**NELSON GEOTECHNICAL  
ASSOCIATES. INC.**

Response to City Review Comments and Geotechnical Plan Review Letter  
**Moran Residence Development**  
**5028 West Mercer Way**  
**Mercer Island, Washington**  
NGA File No. 1211520

This letter documents our geotechnical plan review and response to geotechnical city review comments regarding your planned residence at **5028 West Mercer Way in Mercer Island, Washington.**

**FOUNDATION PLAN**  
SCALE 1/4" = 1'-0"

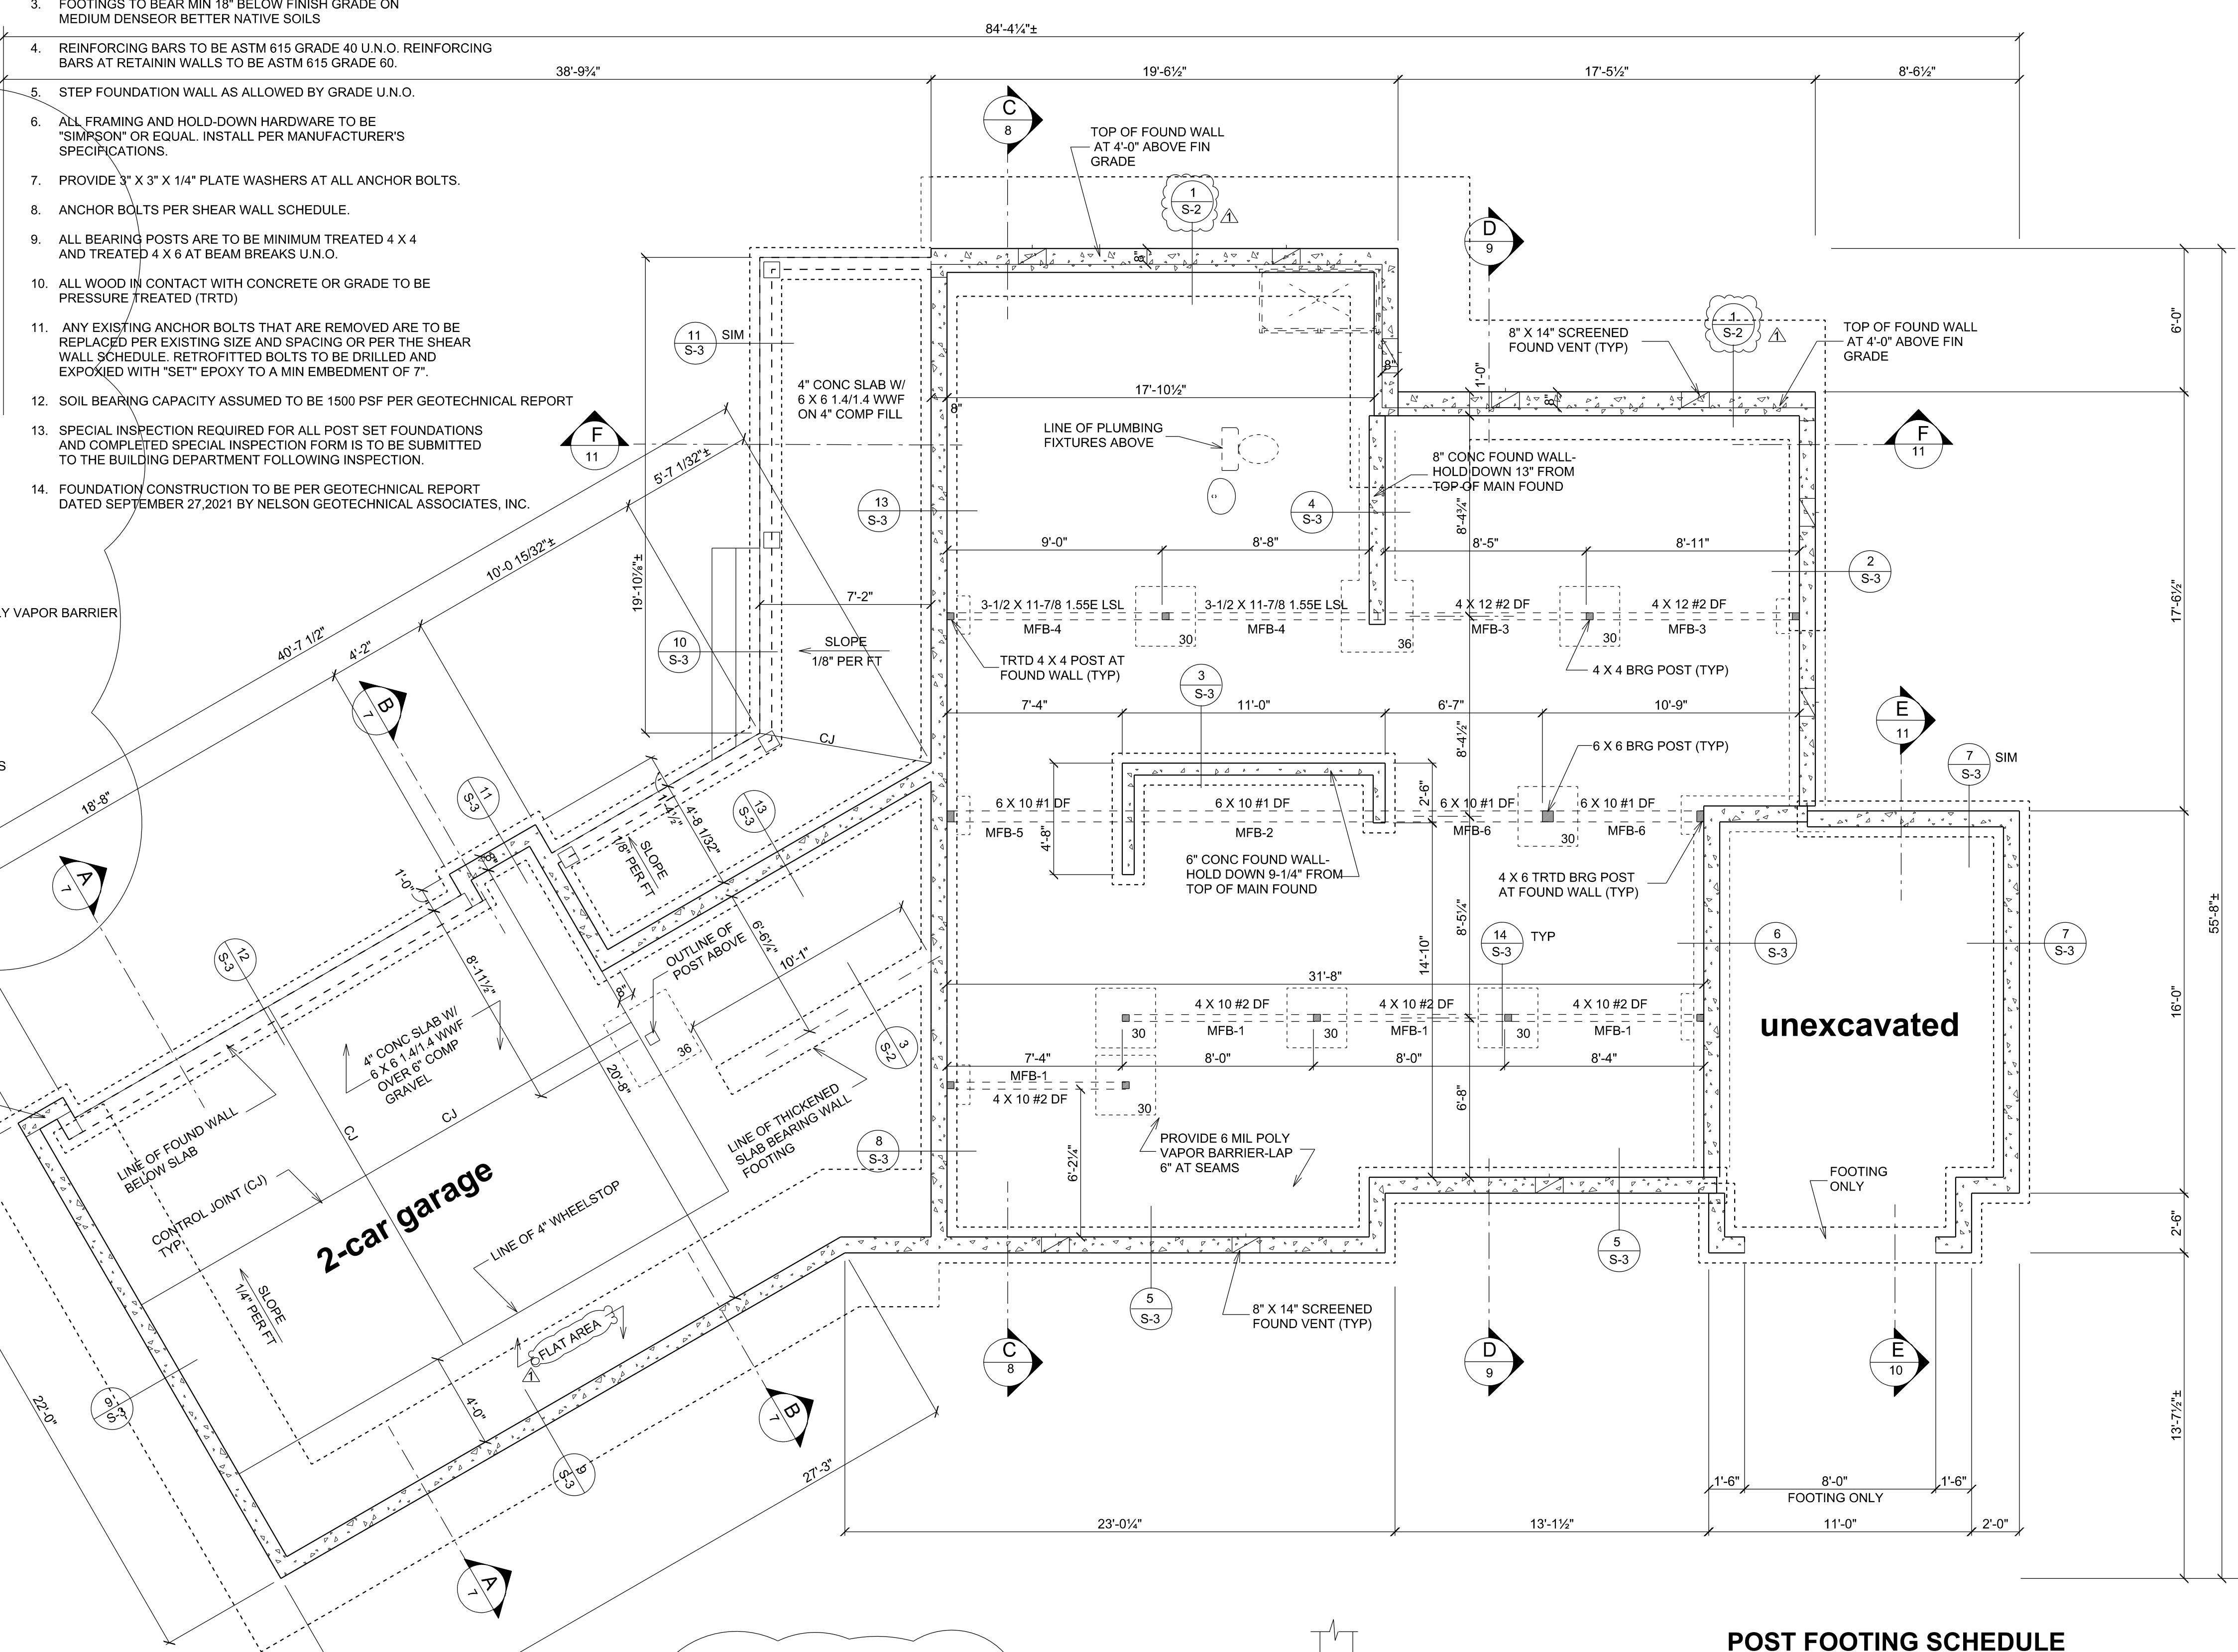
### COMMENT 1: Structural Plans – Sheet S-2

*Is the slope-facing eastern residence foundation wall supposed to be designed to resist potential debris loading and if so, has it been designed with a design pressure of 90 pcf, per the geotechnical engineer recommendations? The geotechnical engineer should also confirm the extents of the debris protection portions of the residence foundation wall.*

We discussed this issue with the project architect and structural engineer. We recommended that the eastern foundation wall be designed with a surcharge of 90 pcf to account for potential debris impact and should apply to all east-facing exterior foundation walls located within 12 feet from the proposed shoring wall. The debris protection foundation wall should extend a minimum of 4-feet above the finished ground surface.

We received an updated copy of Sheet S-2 (foundation plan) and supporting calculations dated March 31, 2023. Based on a review of the provided plans and calculations, it appears the easterly wall has been designed with the recommended values and extents.
